From: Simon Davis
Sent: 22 May 2019 16:34
To: Planning Scanning
Subject: FW: Planning Consultation on FP/42/19/DOC

My comments to conditions 7, 9 and 10 are still outstanding, I have not seen any revised details. Condition 8 can be discharged.

Engineers Comments Regarding Condition 7

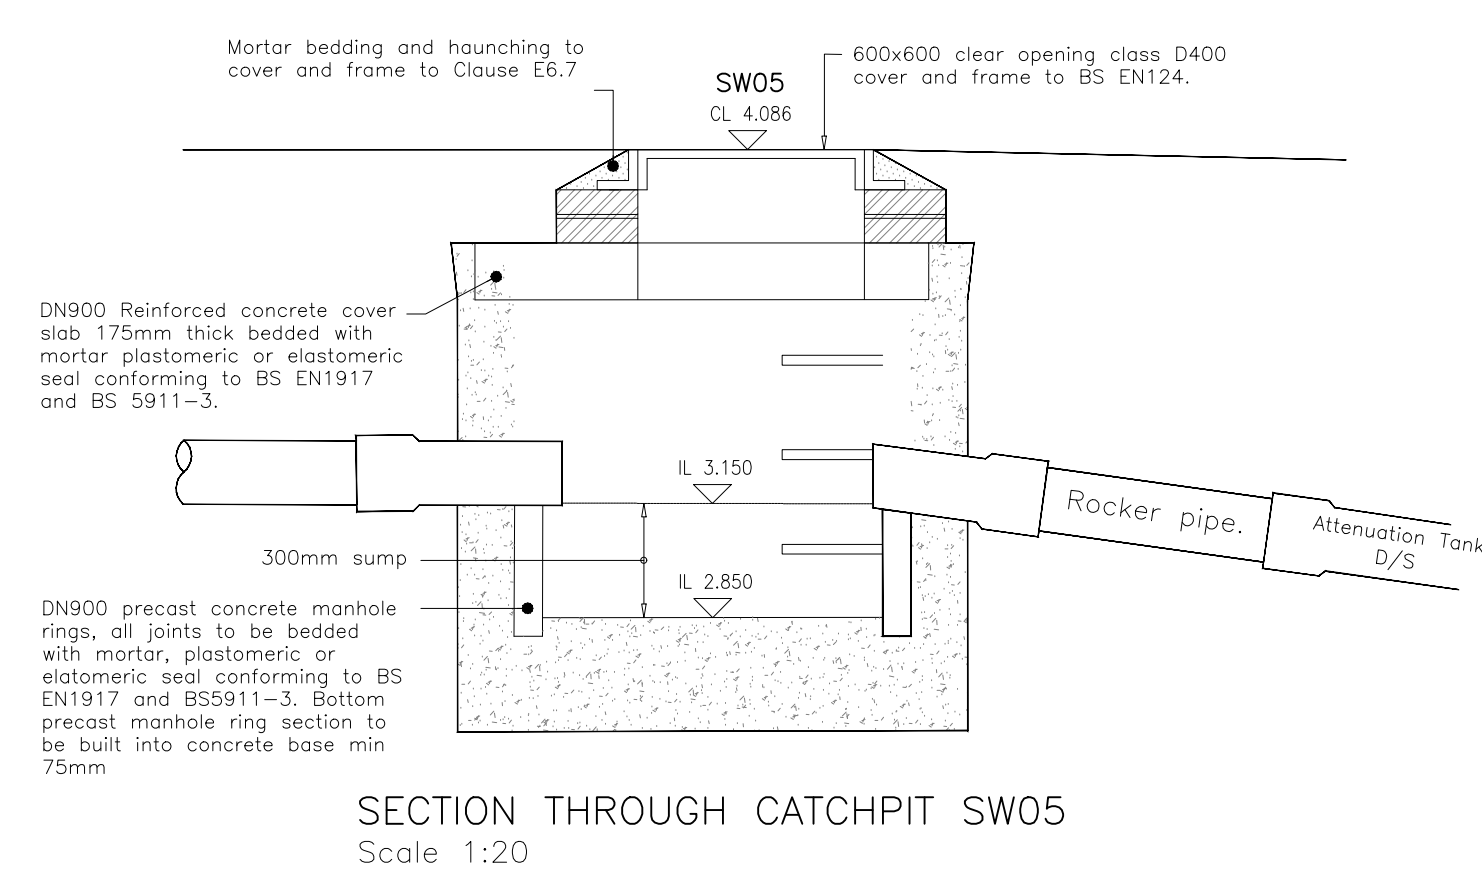
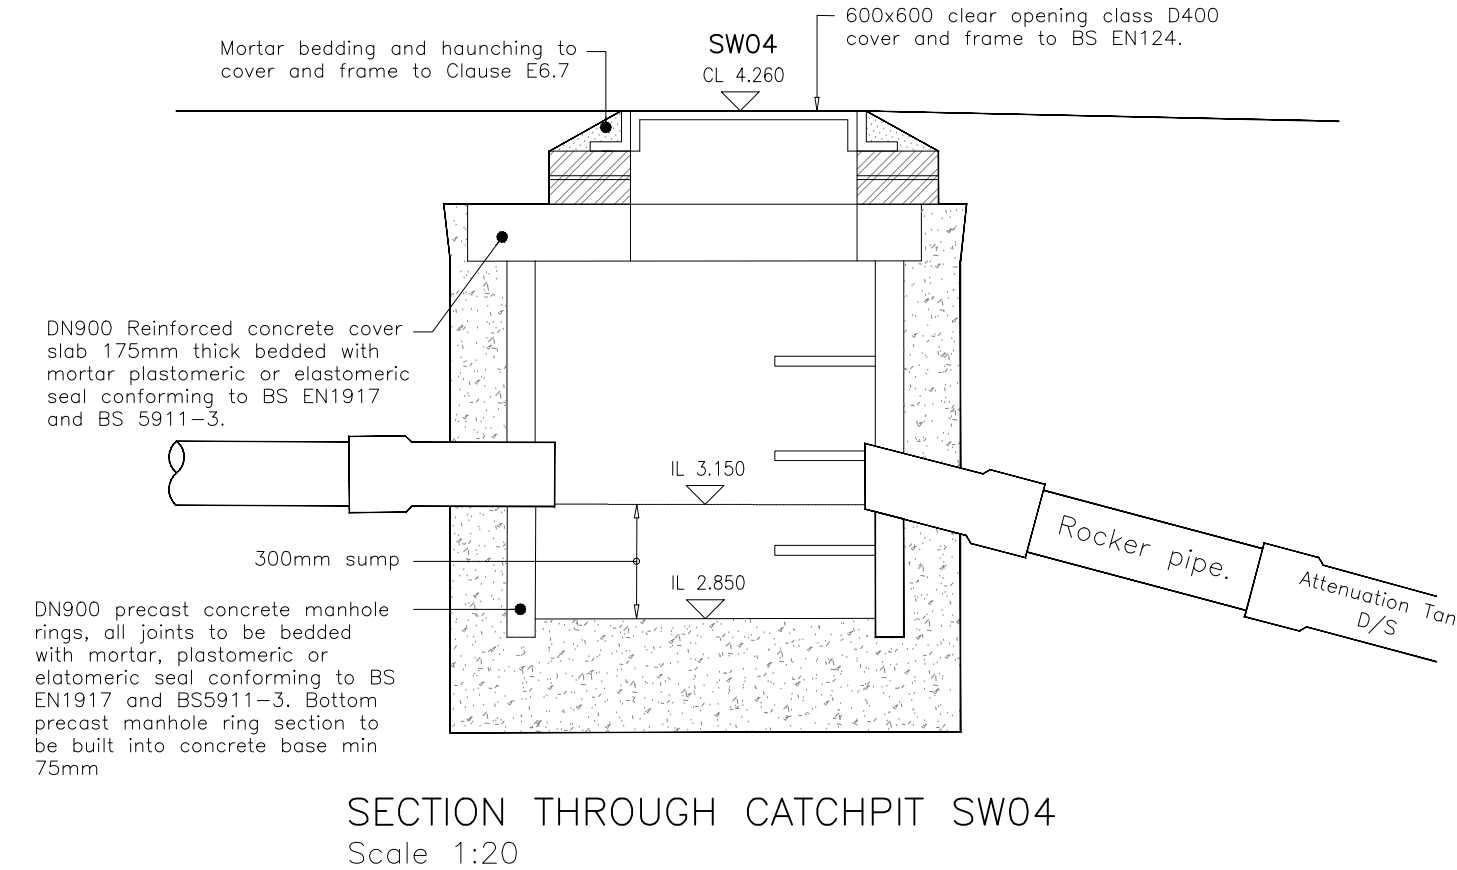
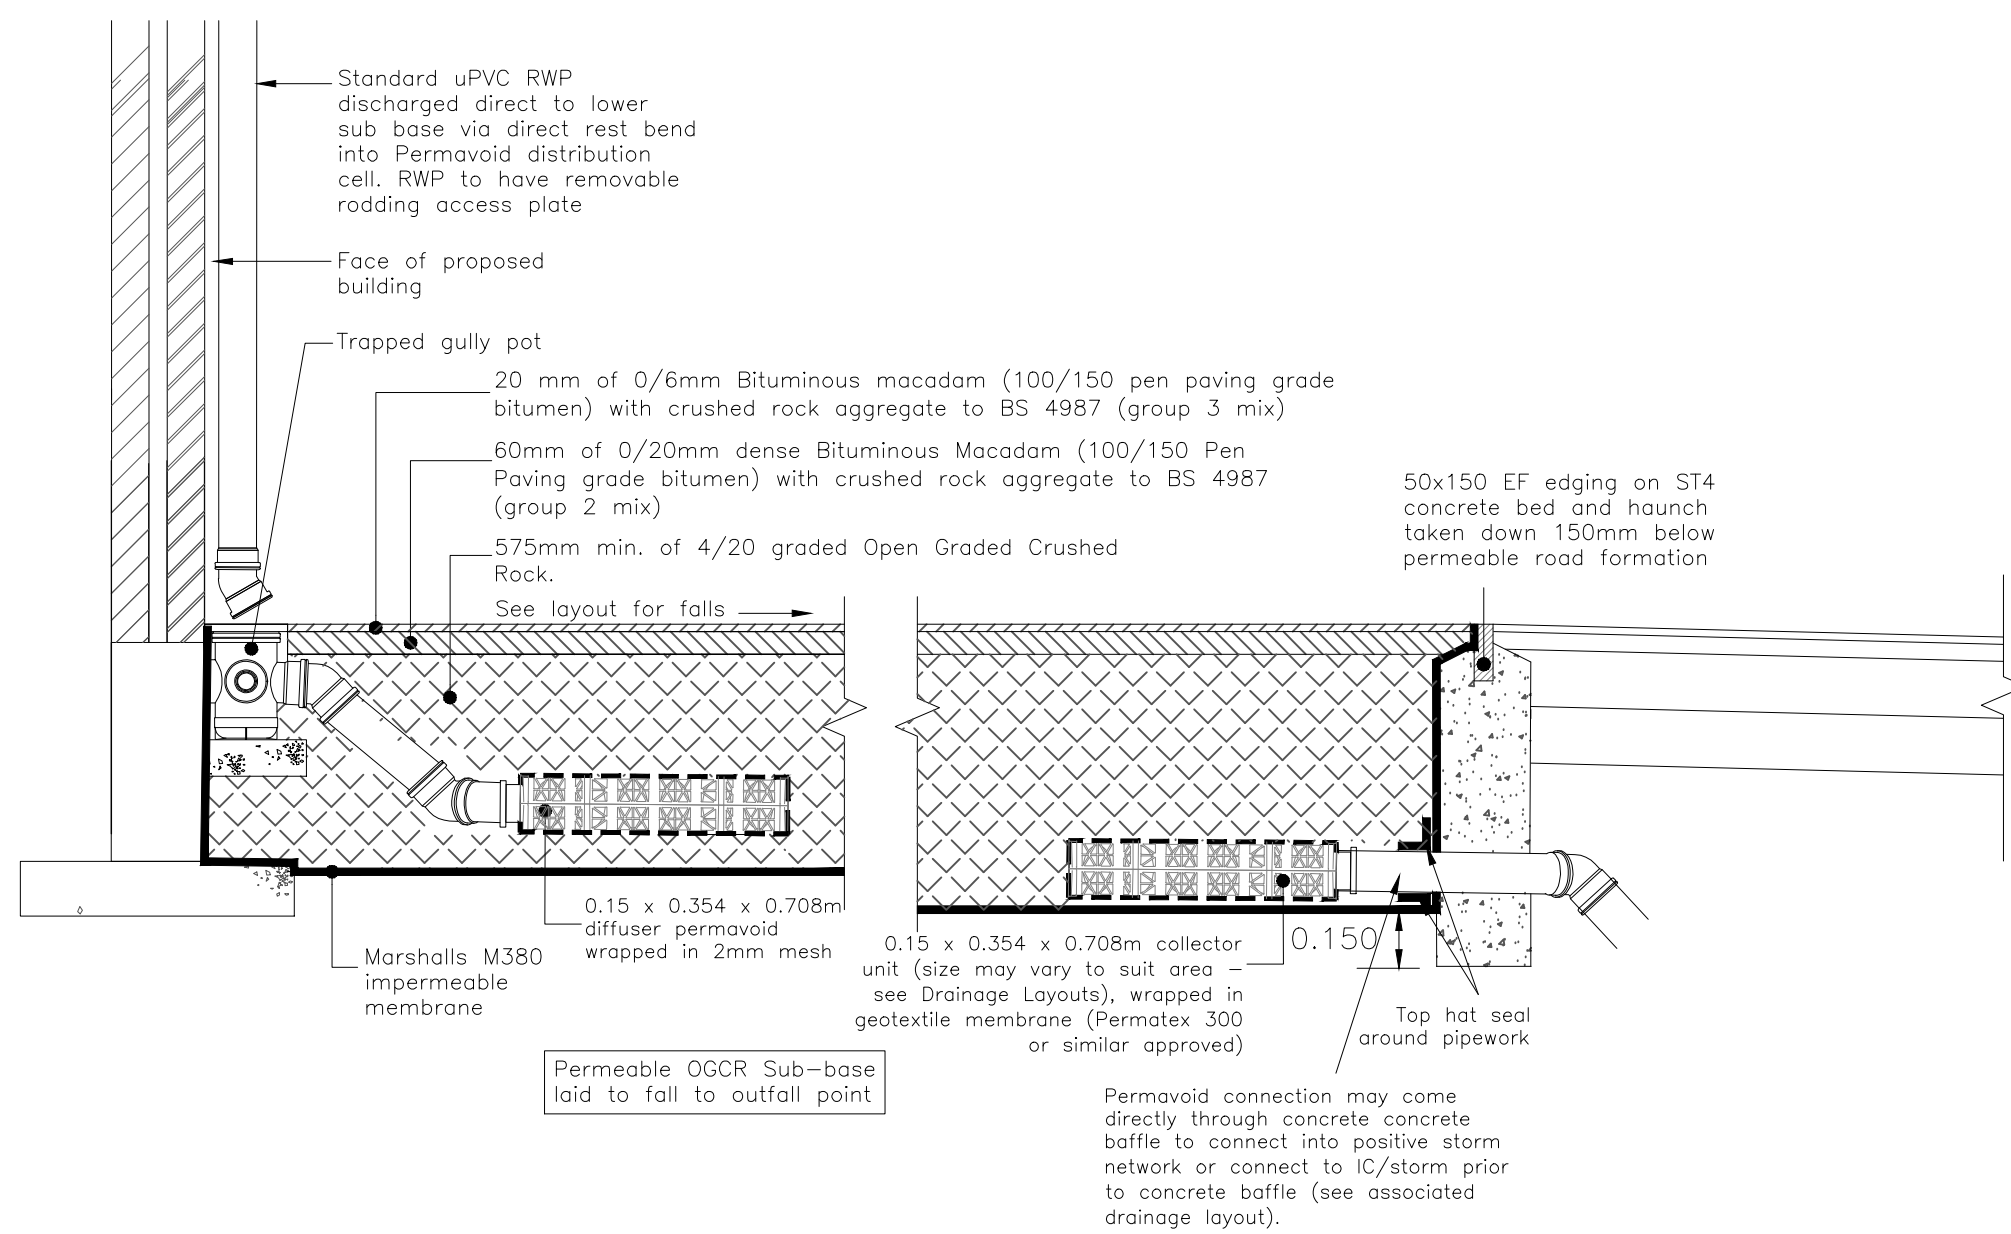
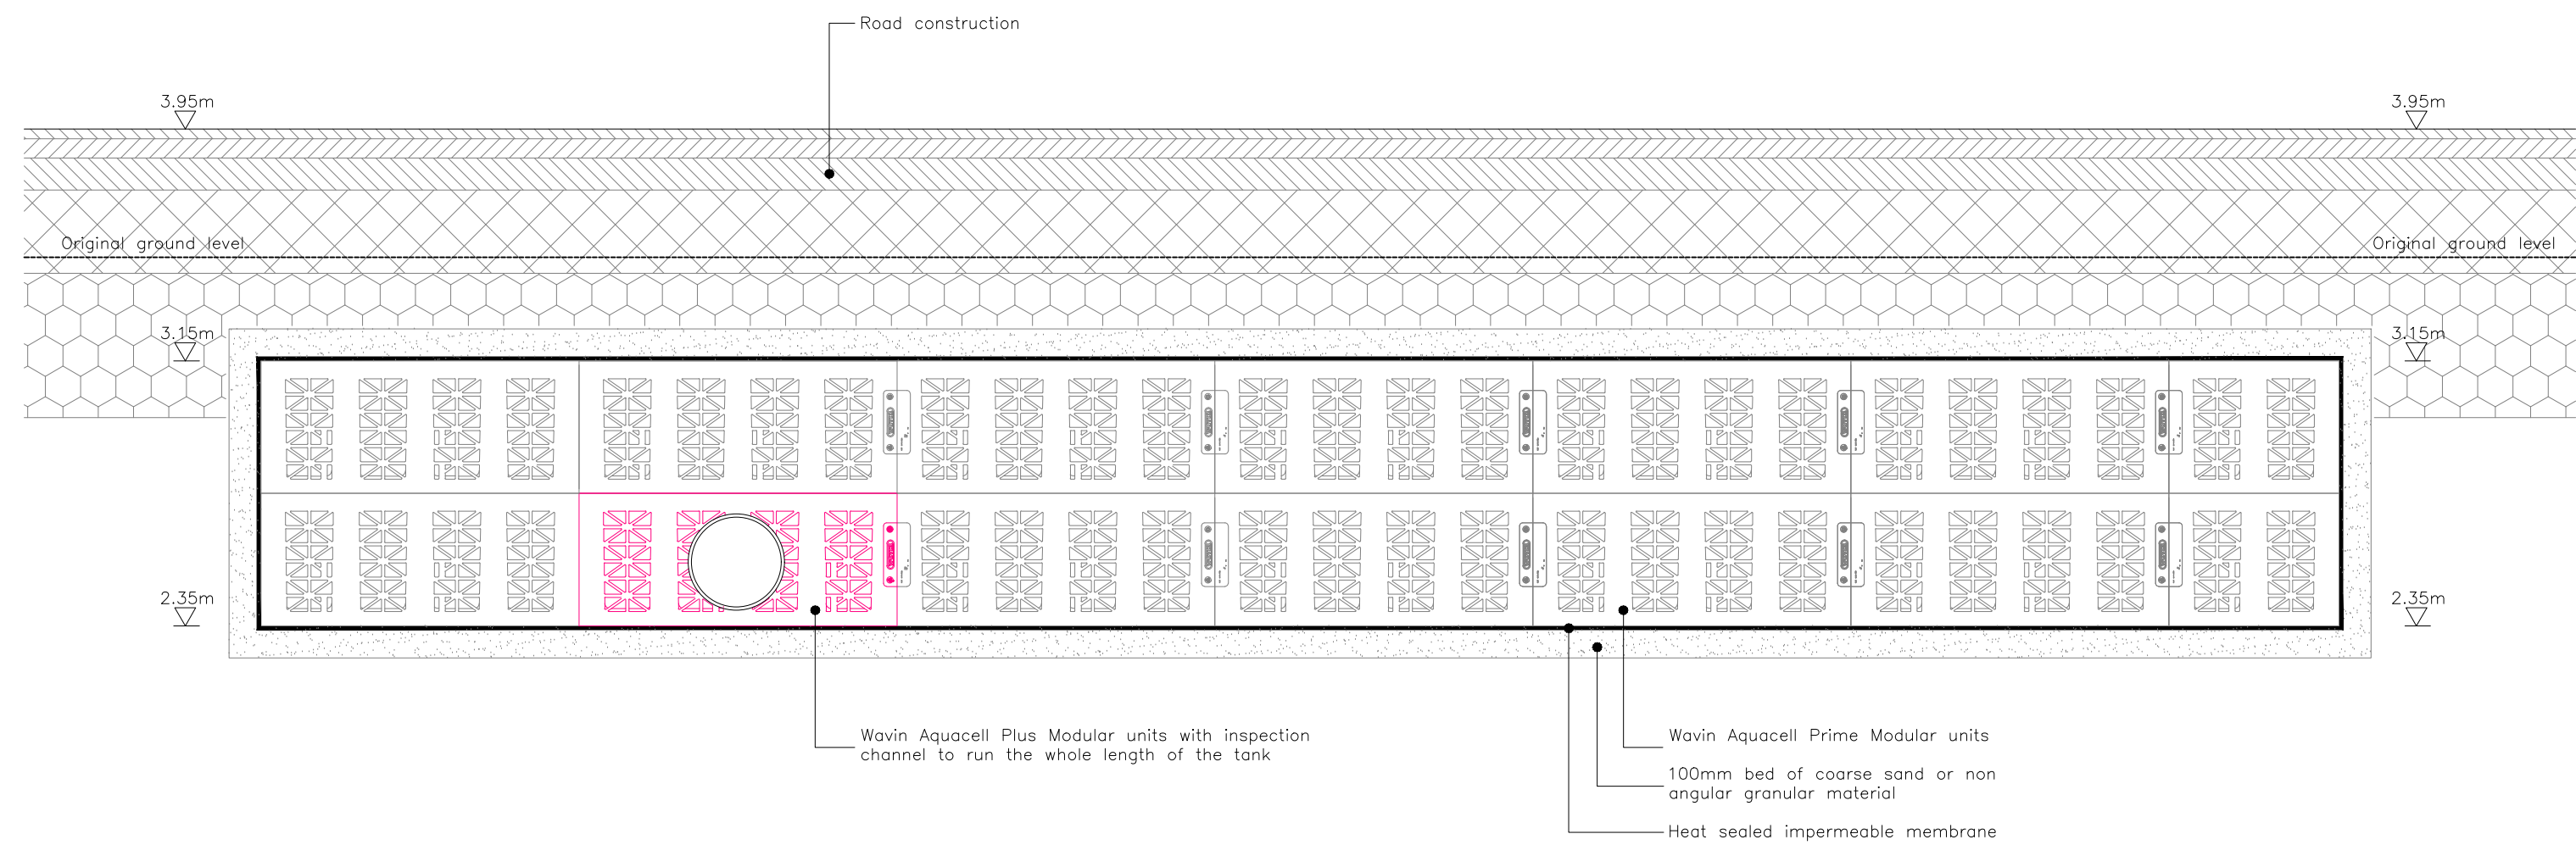
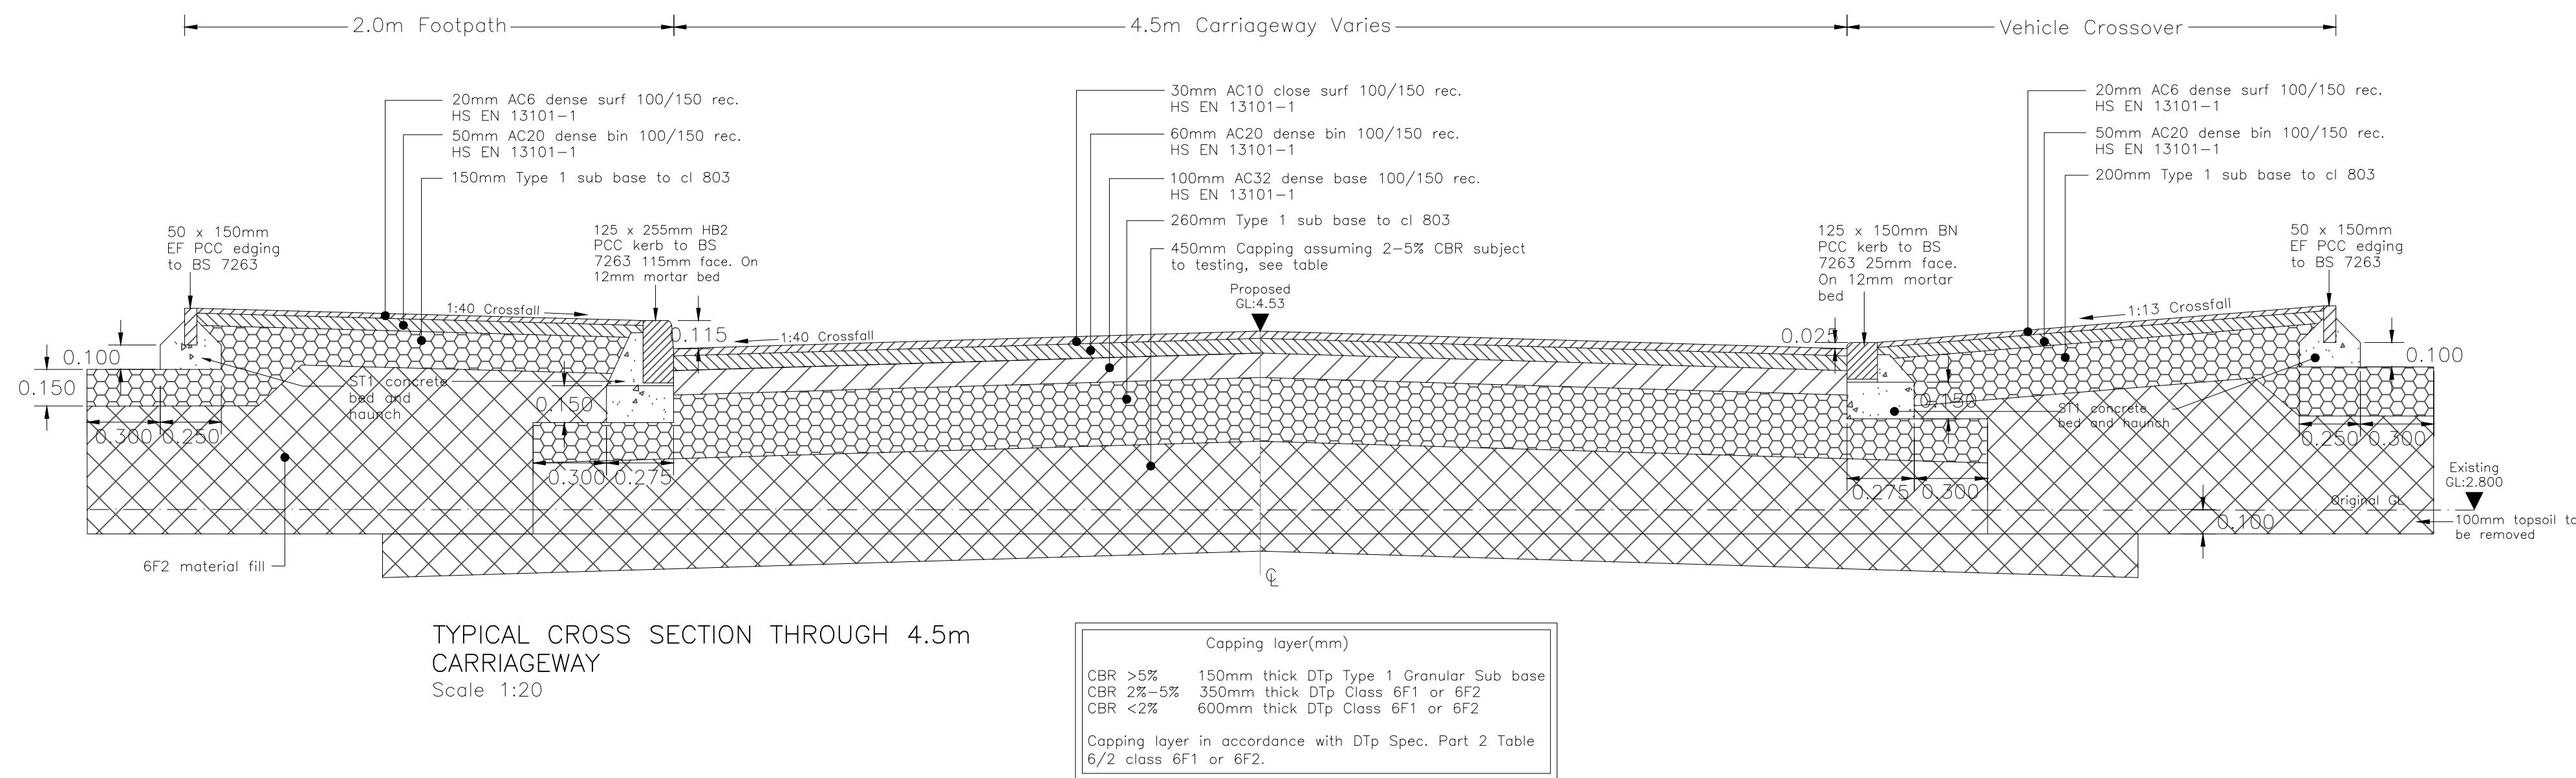
1. Catchpits must be provided upstream of all connections into the attenuation tank.
2. No construction detail drawings have been provided. Please provide construction detail drawings of manholes, catchpits, permeable paving, attenuation tank and hydrobrake.
3. There is conflict between the landscaping proposals and the drainage proposals. Trees must not be located on or near attenuation tanks. Please revise the landscaping proposals.
